Cockle Bay Park – Response to Government, Agency, and Organisation Submissions

Southern position

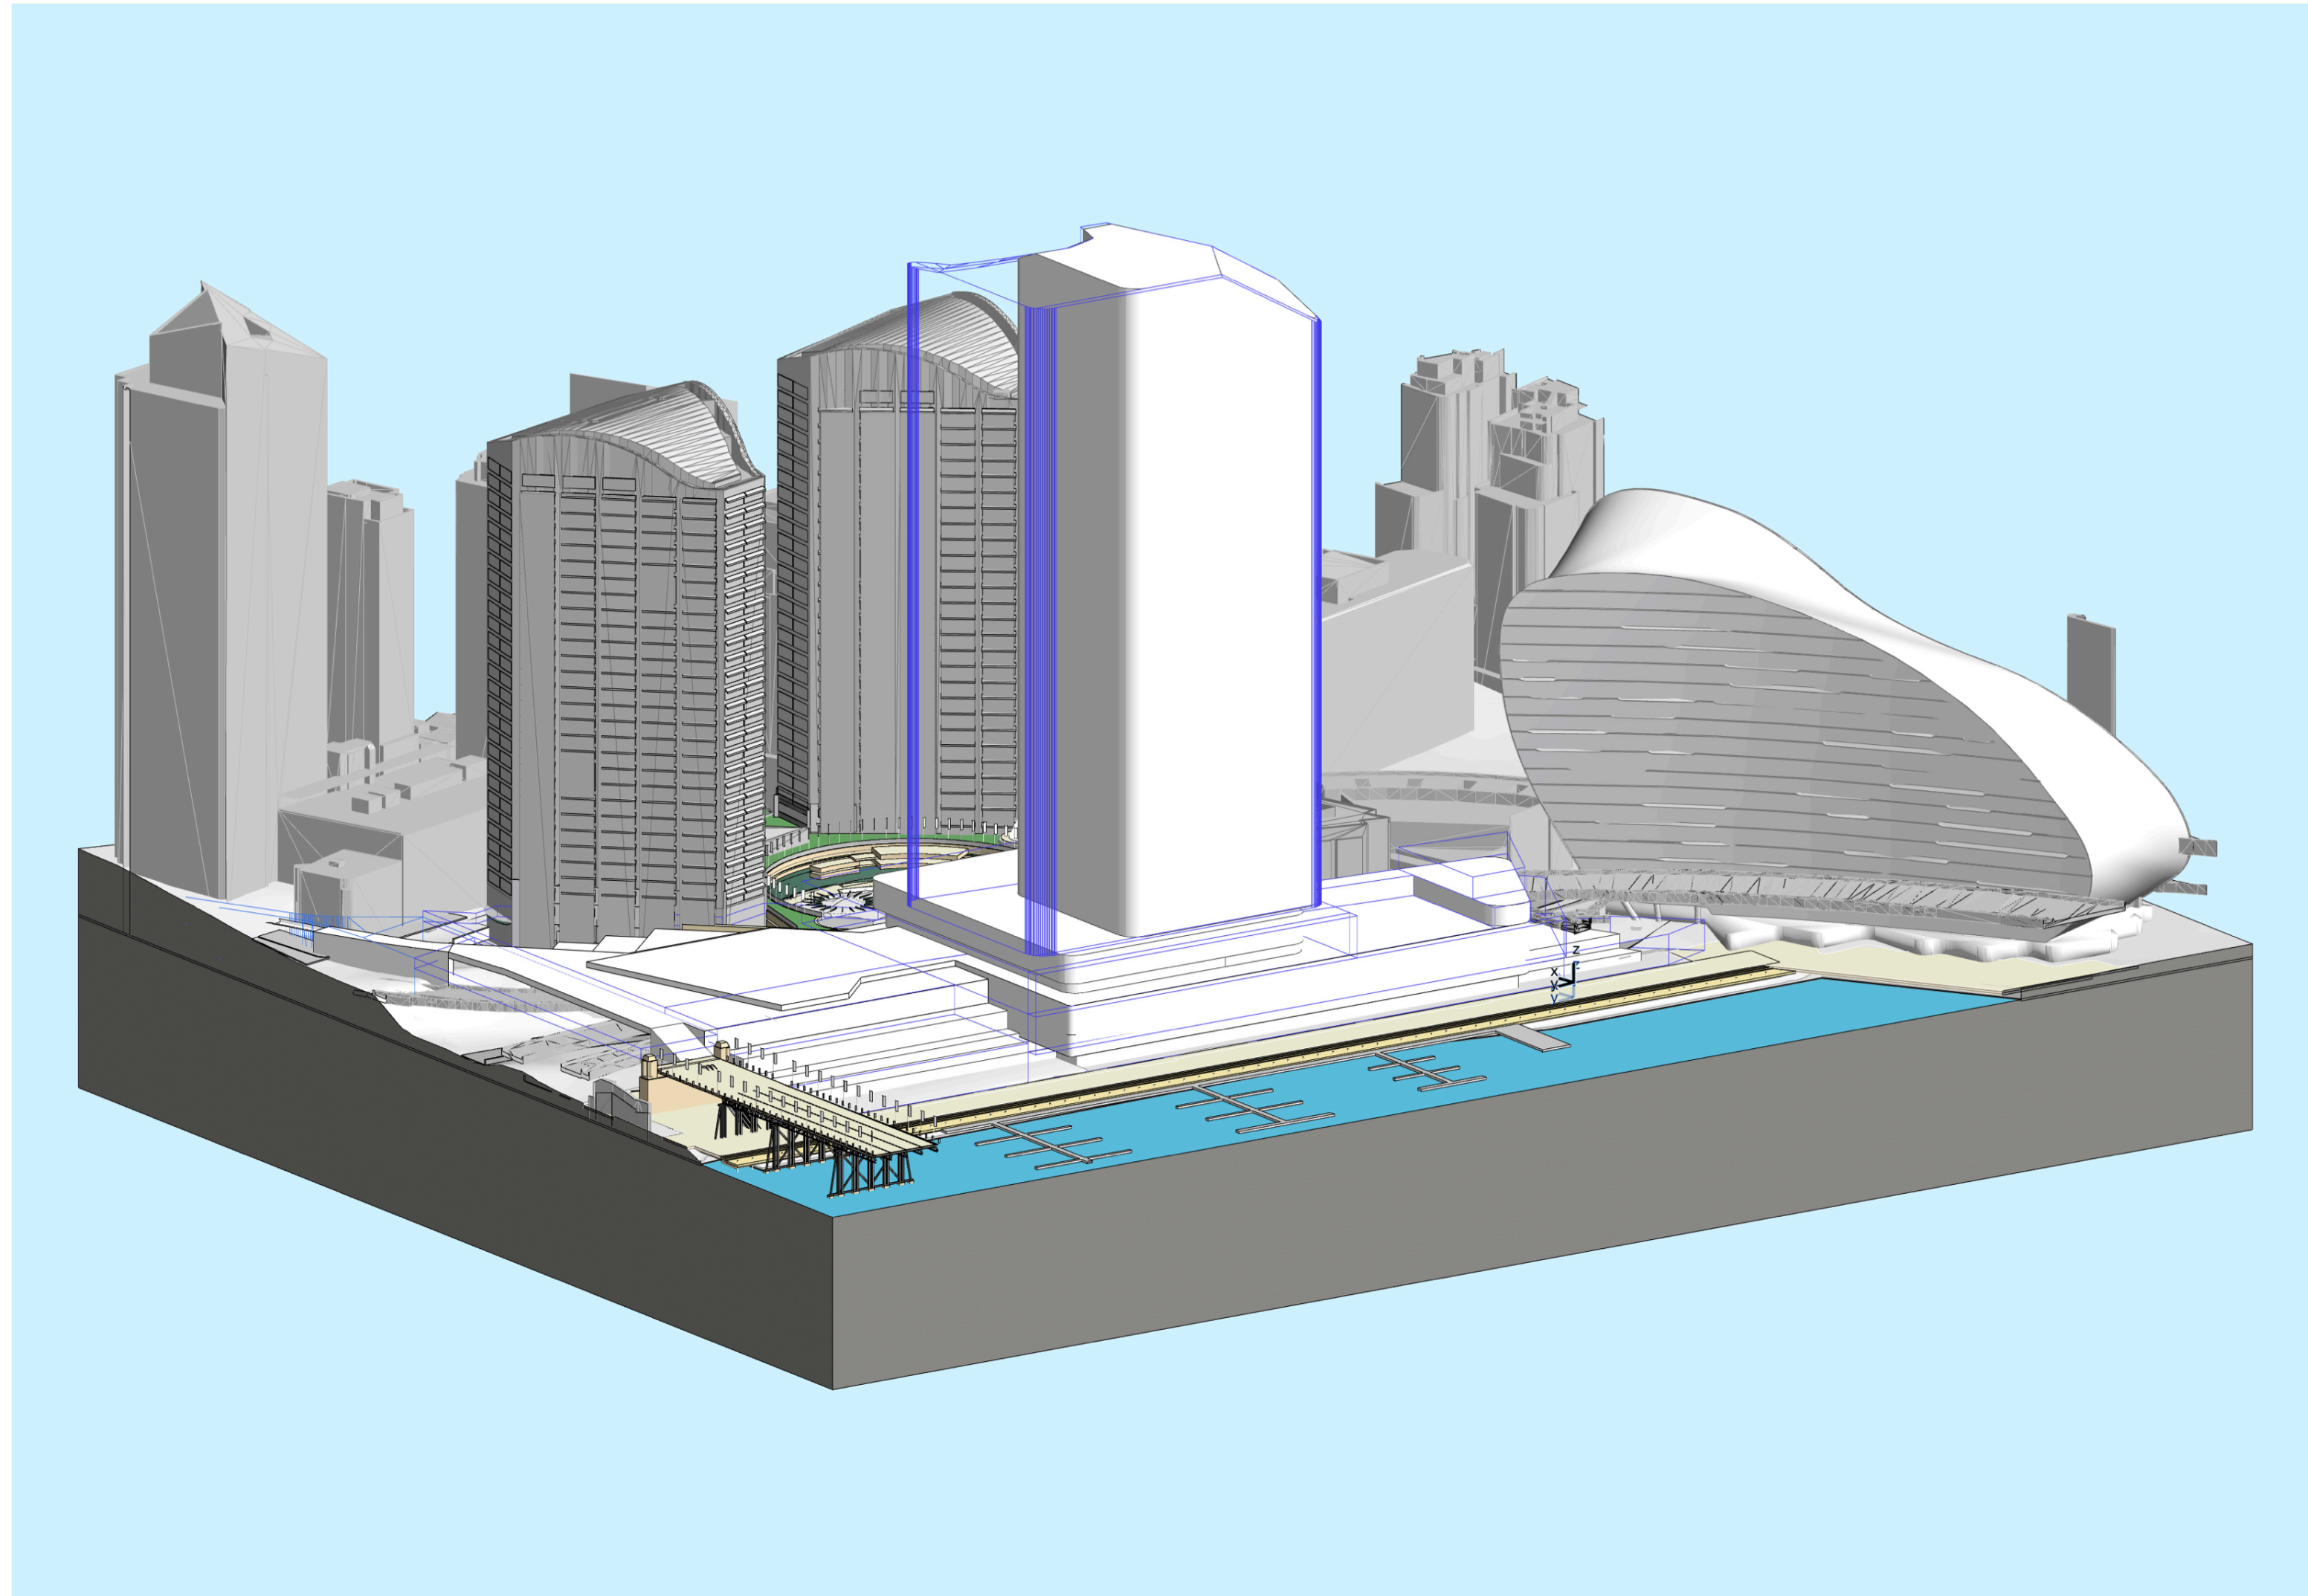
Tower Siting	
Further justify the tower location, including analysis of alternative locations considering benefits/impacts of each.	Following the exhibition of the EIS the proponent has engaged in a series of design development workshops with the Department's urban design consultant and the proponent's design excellence team. The outcome of these workshops has been documented within the Response to Submissions document (refer to Section 3.0). The location of the tower form within the site allows for flexibility of outcome through the competitive design process and therefore proposes a larger area than would be occupied by any future built

Item Raised	Proponent's Response
	<p>form. However, within the envelope various built form outcomes have been deemed acceptable where accompanied by further built form controls</p> <p>Further justification for the location of the tower envelope and built form controls has been provided within Section 5.2 and Appendix C</p>
<h3>Private View Impacts</h3>	
<p>Additional view impact analysis required, including:</p> <ul style="list-style-type: none"> - Comparative analysis of existing and proposed reduced view/cone from the Sussex St properties - Identification of the levels and units where water views and views to Pyrmont Bridge can be obtained and will be affected - Detailed response to submission from 222 Sussex St and associated view analysis - Further consideration of the tower height impacts on water views due to relative angle of depression 	<p>A supplementary View and Visual Impact Analysis has been prepared and is provided as Appendix D. This supplementary impact analysis provides an update on the previously submitted impact assessment to address changes to the design of the Concept Envelope and also includes a detailed assessment of view loss from neighbouring residential buildings where access to these apartments have been provided. This private view analysis has had regard to relevant Planning Principles for View Impacts. Refer to Appendix D and to Section 5.4 of the RTS for additional information.</p>

Investigate the provision of cycleway connection via the development between:

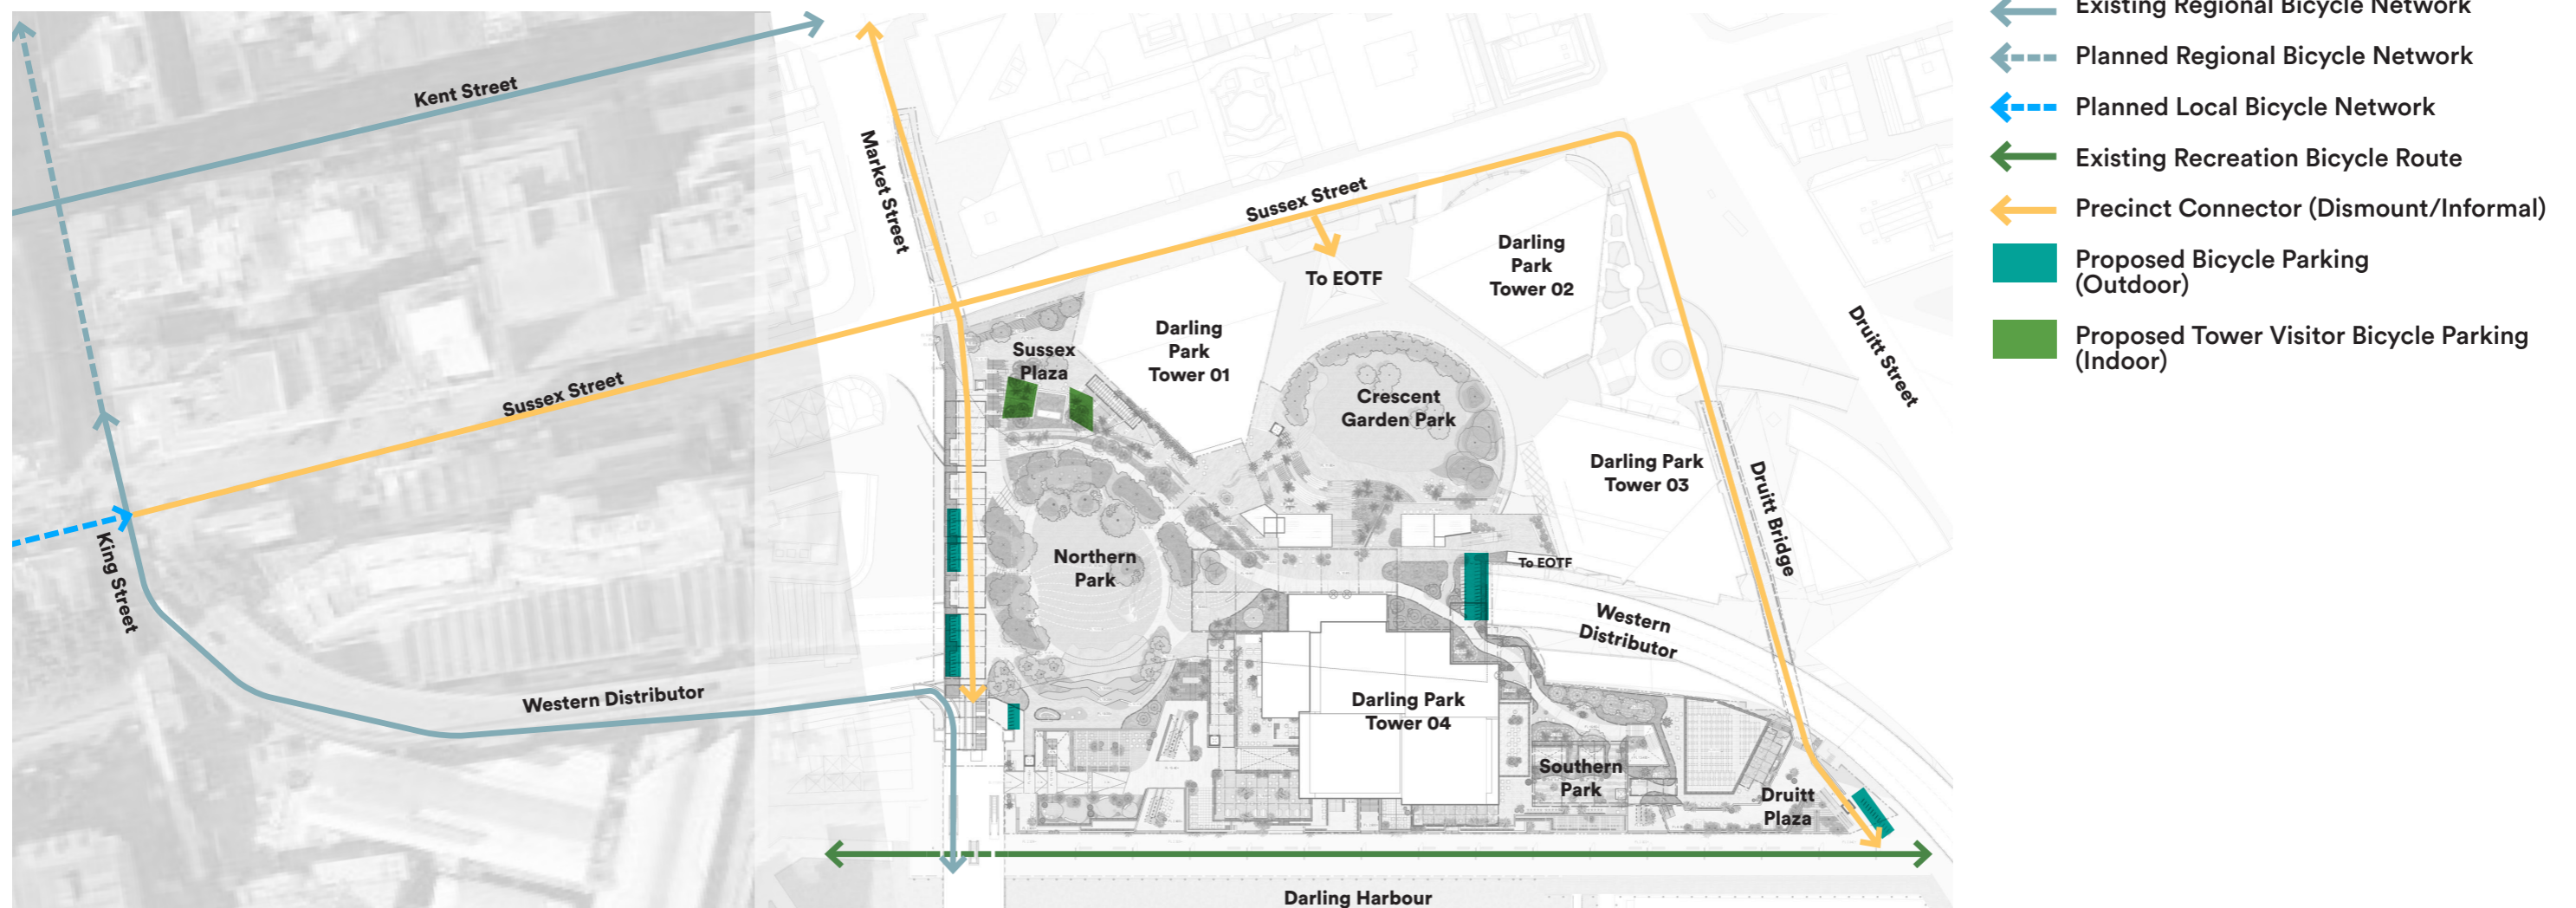
<p>The applicant consider connecting existing pedestrian/cycle infrastructure on the Western Distributor with the King Street and Kent/Liverpool Street cycleways via the development site, as part of the development, in consultation with the Sydney Coordination Office within TfNSW.</p>	<p>Agreed, these requirements could form part of the design objectives for the competitive design process brief, as it relates to the design of the new open space.</p>
<p>Construction Pedestrian and Traffic Management Plan</p>	
<p><u>Comment</u></p> <p>It is noted that the proposal seeks concept approval for the construction of new buildings which would be proposed under a Stage 2 development application. TfNSW advises that several construction projects, including the</p>	<p>Noted.</p>
